Our ref: DOC19/913151
Senders ref: SSD-9472

Subject: EES comments on the Environmental Impact Statement for Sikh Grammar School –
SSD-9472 - 151-161 Tallawong Road, Rouse Hill

Subject: EES comments on the Environmental Impact Statement for Sikh Grammar School – SSD-9472 - 151-161 Tallawong Road, Rouse Hill

Martens & Associates Pty Ltd ABN 85 070 240 890

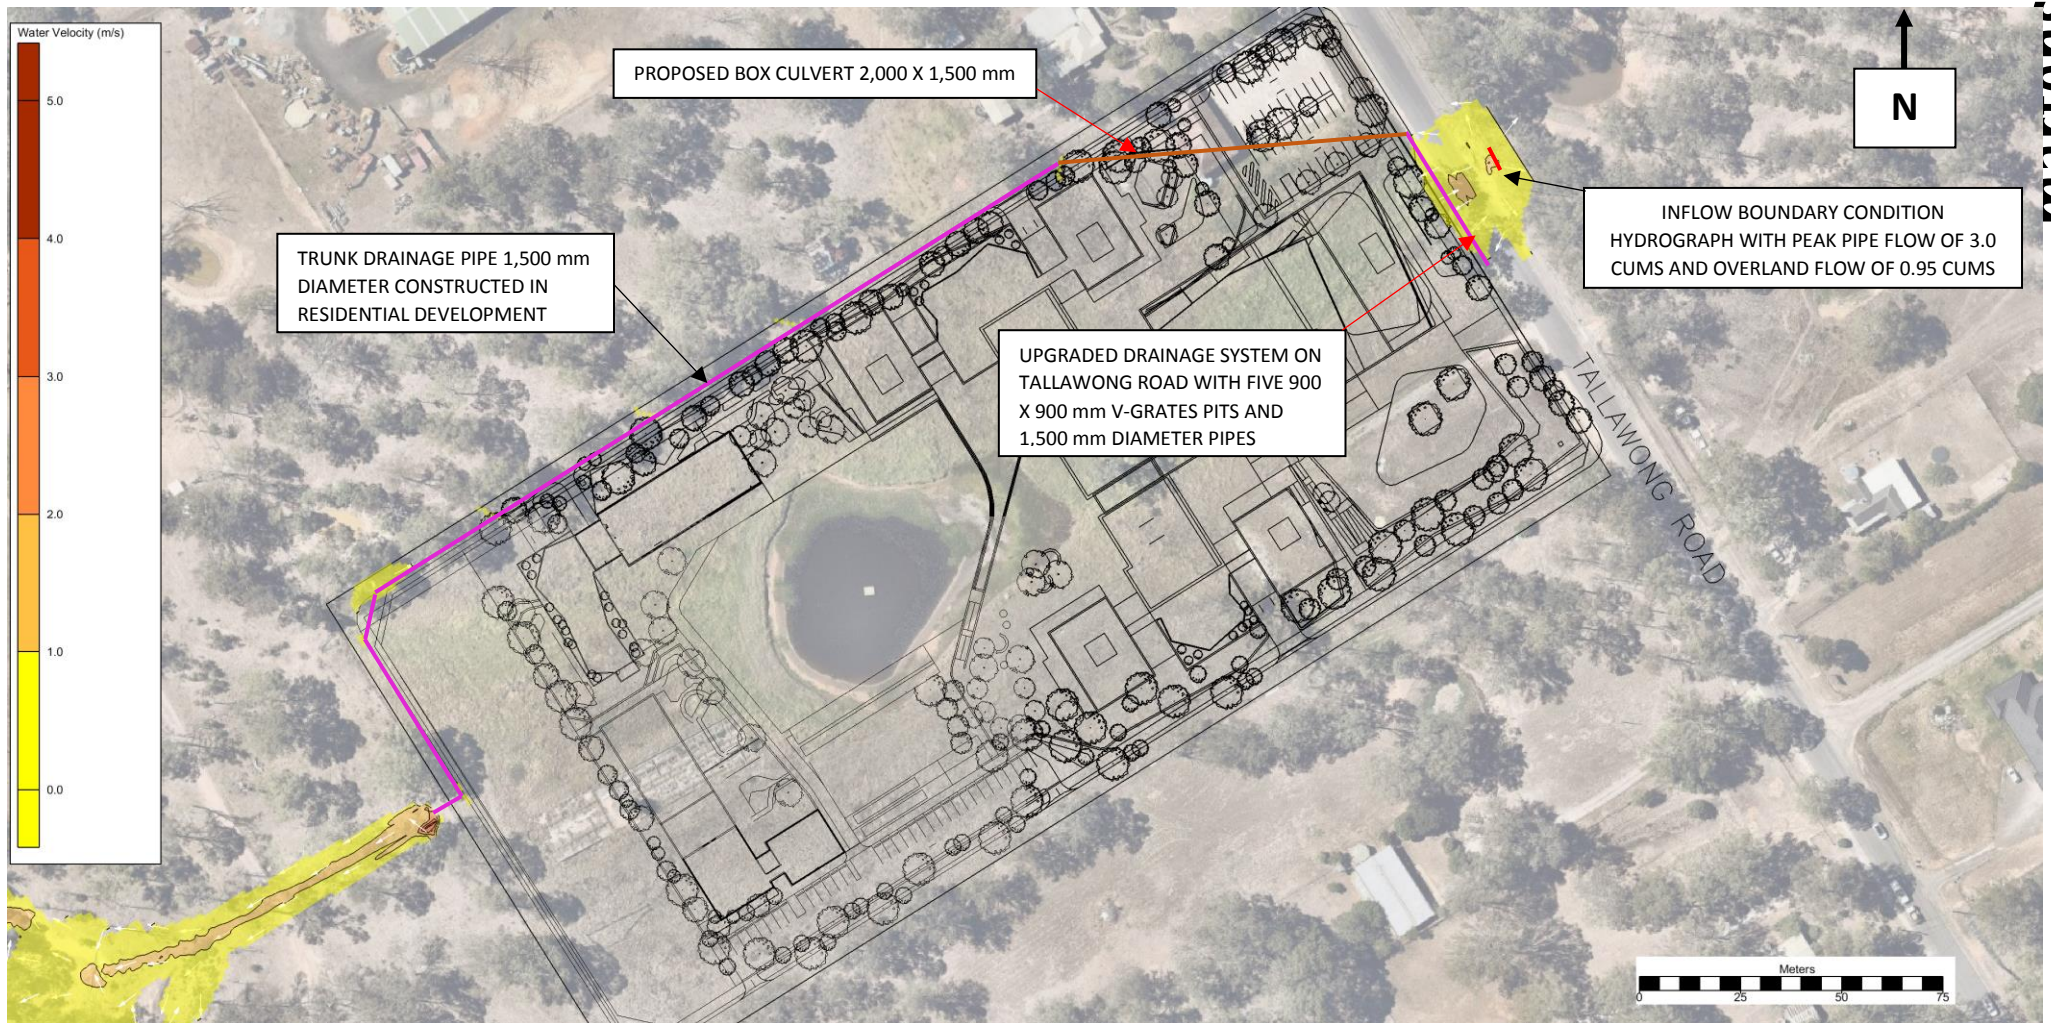
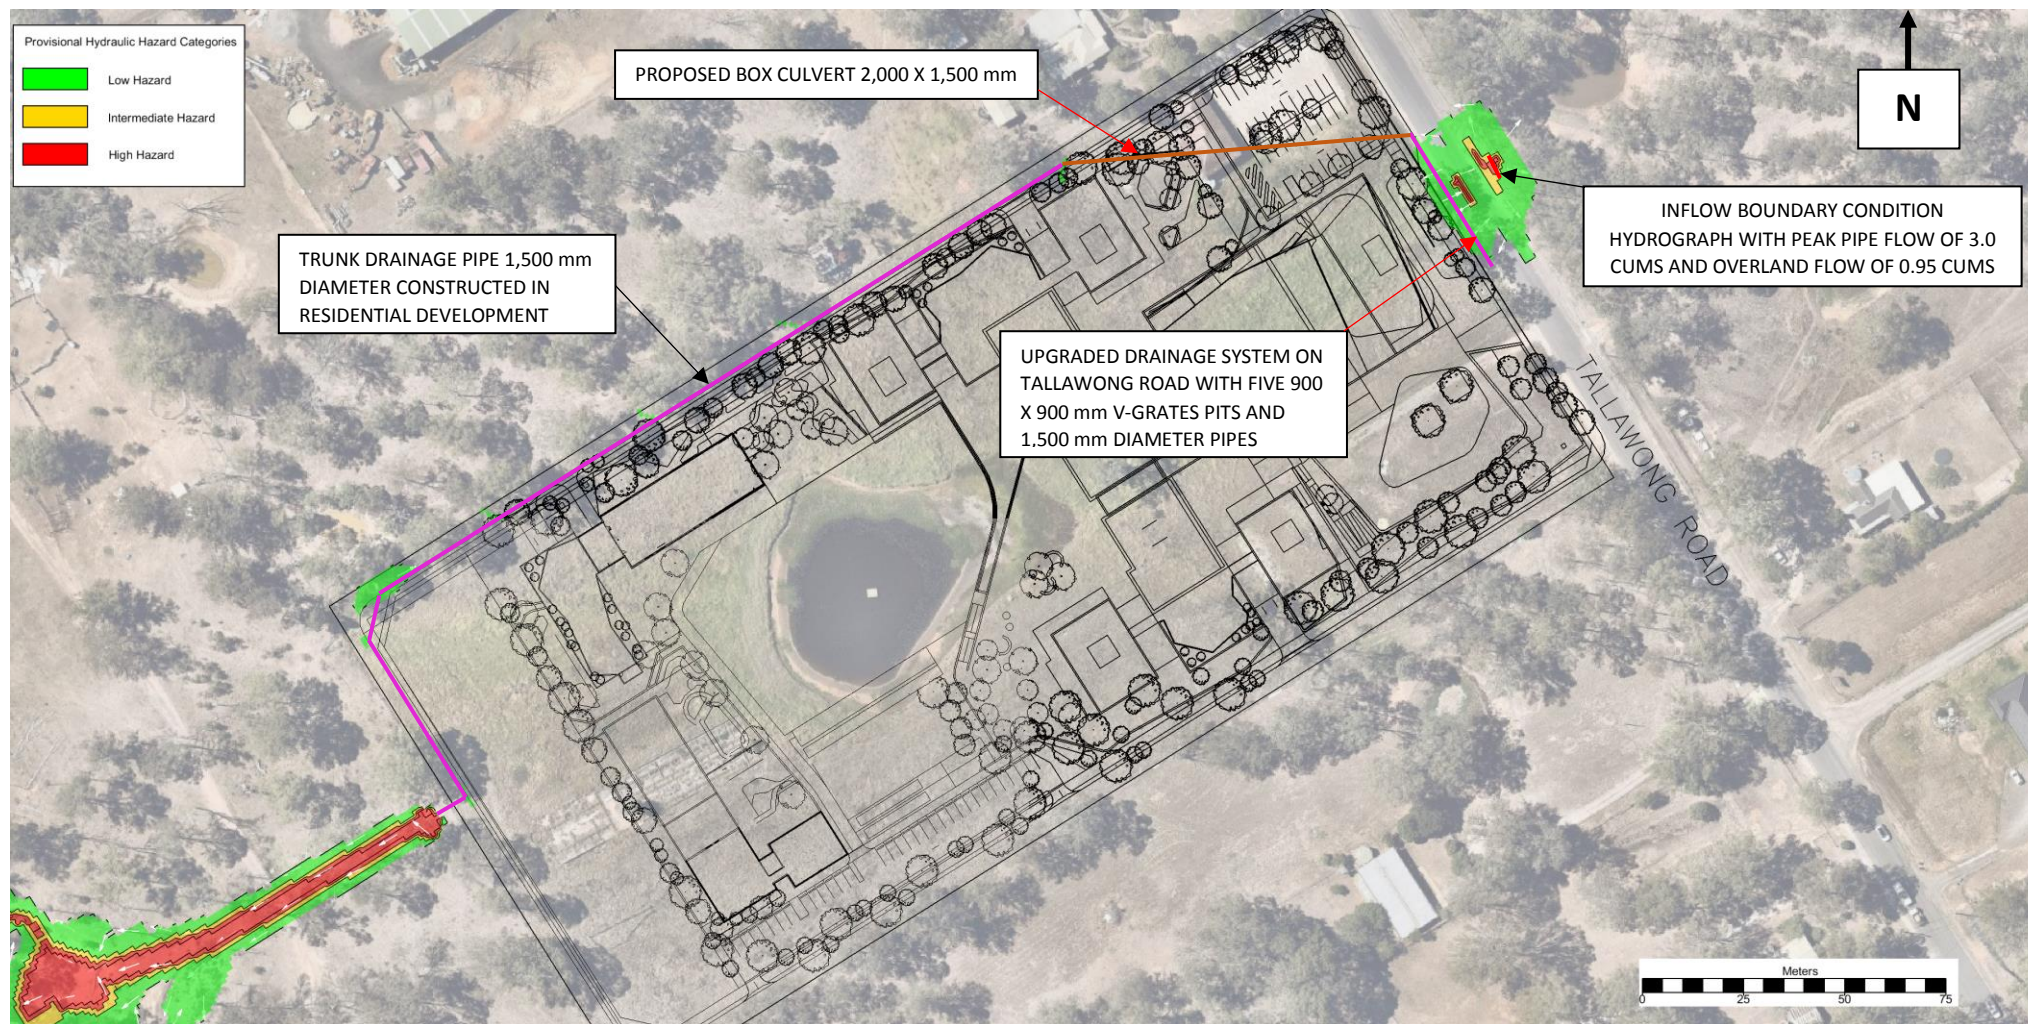
- Figures 3 to 5 of the report shows the site is significantly impacted by the 1% AEP in existing condition. Figure 6 to 11 shows no impact by the 1% AEP in the proposed condition due to the proposed drainage system.

- The report does not provide information whether the project results in any adverse impacts on adjacent and neighbouring properties. These impacts should be addressed and documented.

FIGURE 12

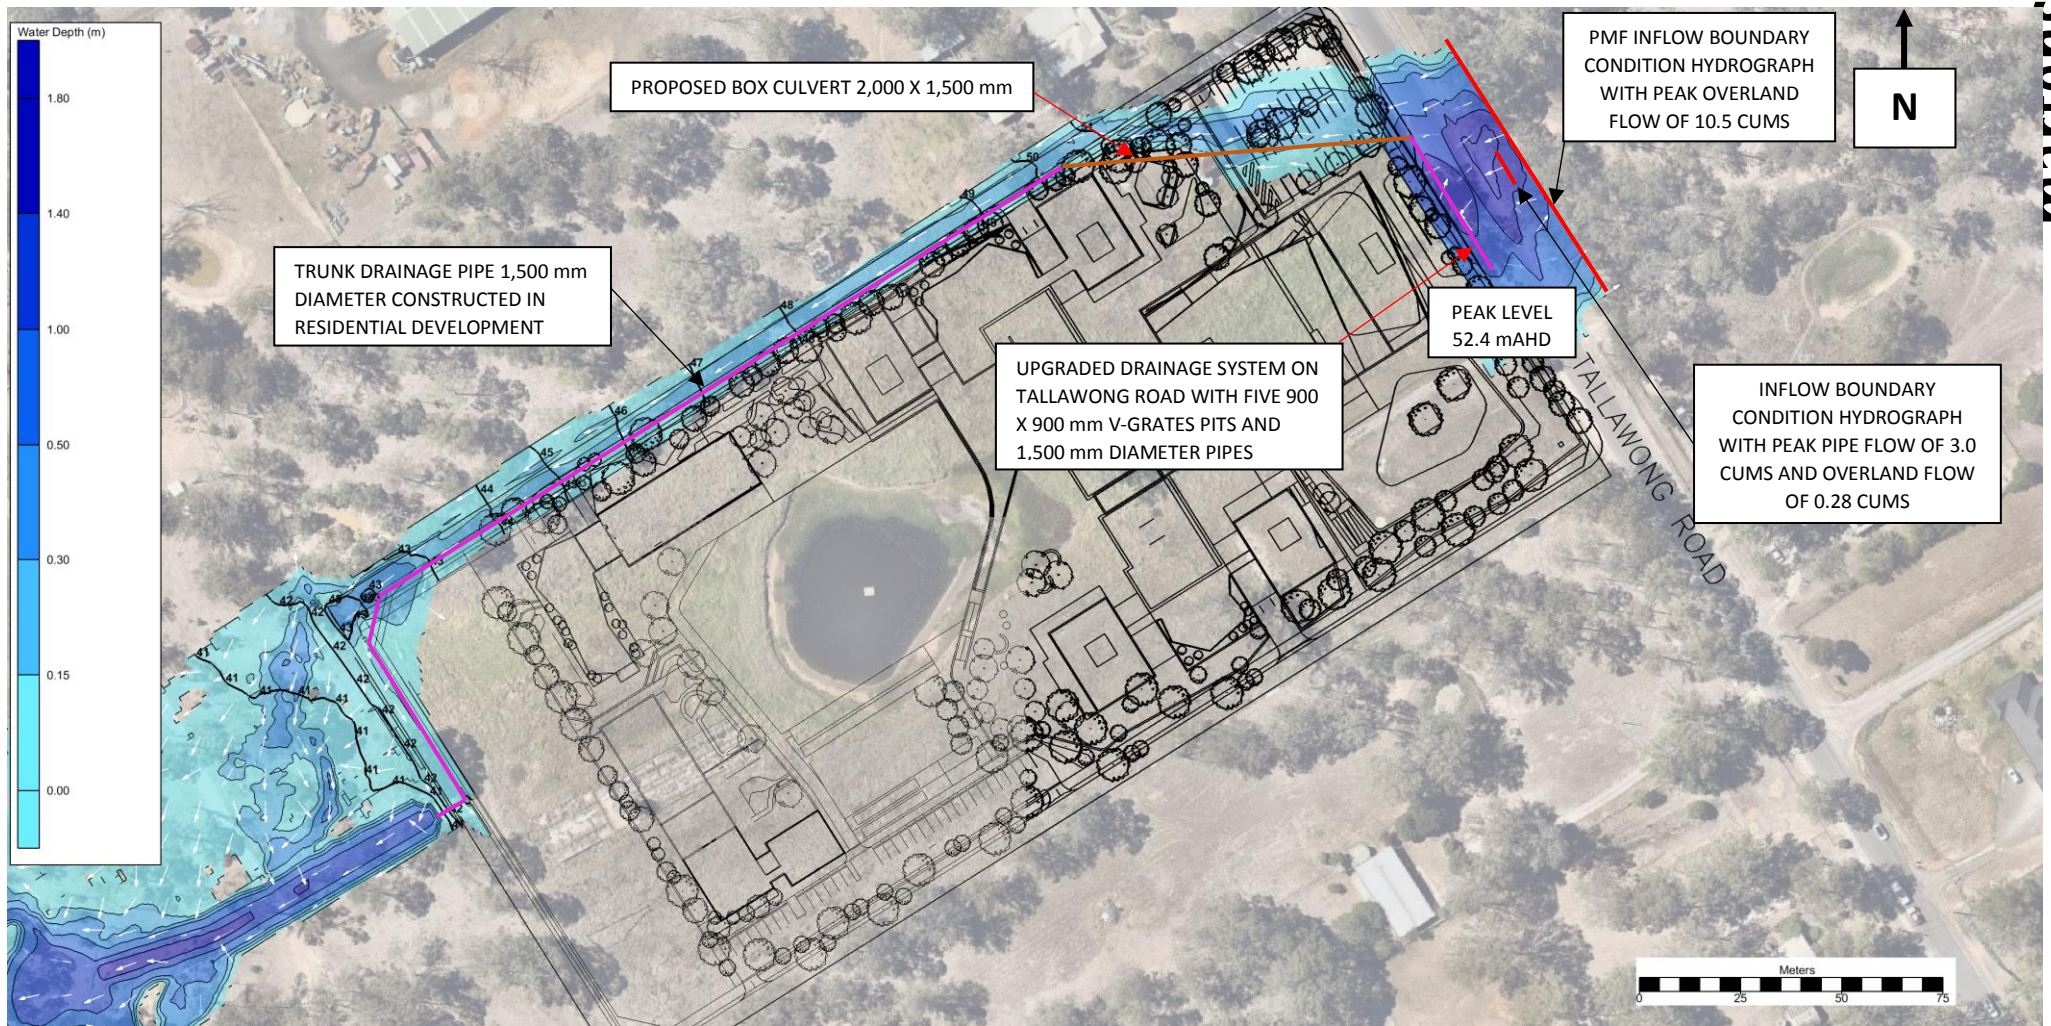
- The project is impacted by the PMF as shown in Figure 12. The northern proposed road and footpath access to the school will be cut off by flood water.

- EES recommends that, an emergency response plan is prepared, including safety signs, along the proposed road and footpath, at the access to underground parking to the north and at the carpark at the north east corner of the site. The preparation and implementation of an emergency response plan will help ensure the safety of students, teachers, parents, carers and other members of the school community.
